JAYNES PROPERTY SKETCH PLAN

LETTER OF INTENT

FILE #: SKP-22-005

SECTION 28, IN TOWNSHIP 12 SOUTH, RANGE 65 WEST OF THE 6TH PRINCIPAL MERIDIAN, EL PASO COUNTY, COLORADO
SKETCH PLAN

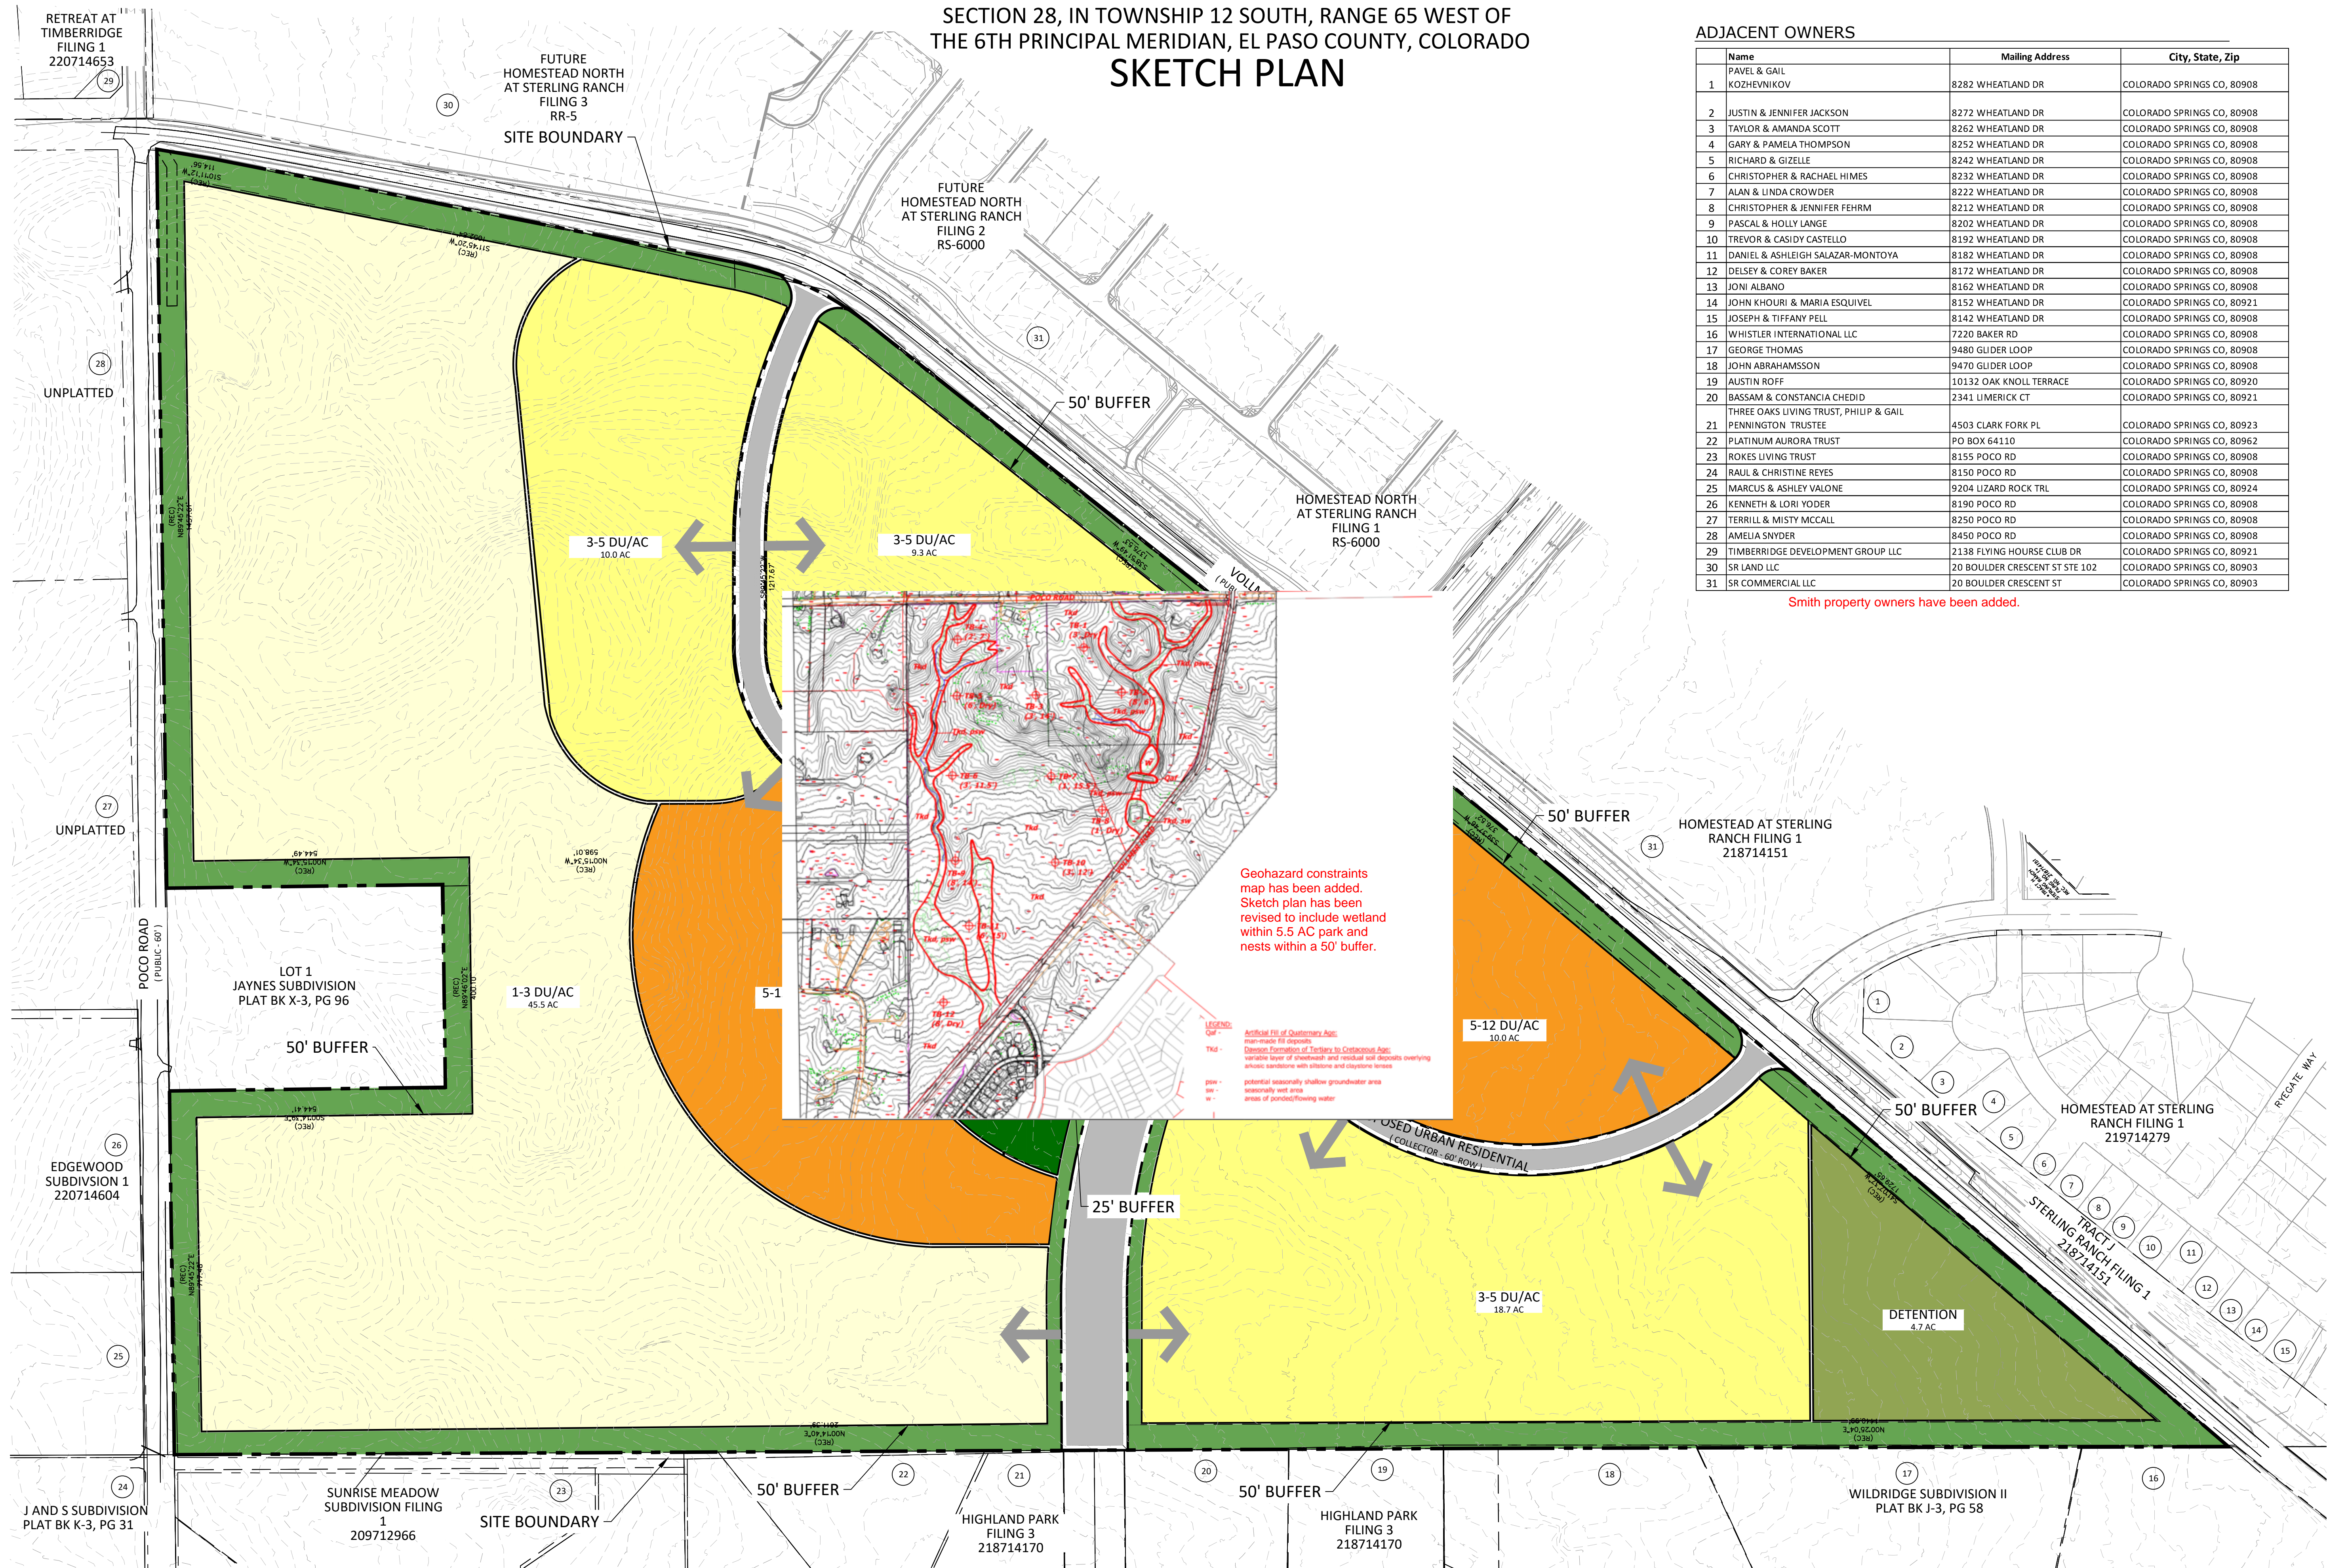
is adjacent to Poco?

This is confusing is there a trail along Vollmer connecting the parks? And is there also a trail along the western boundary that will connect also? Sidewalks will also provide connectivity throughout the development-yes.

Revised to "All proposed access points, including access to Briargate Parkway, and the design of the proposed roundabout will be reviewed with the subsequent preliminary plan"

There is a proposed trail along the western boundary, through the southern 2.6acre park and along Briargate Parkway. There is a proposed Sand Creek Trail Connection at Briargate and Vollmer.
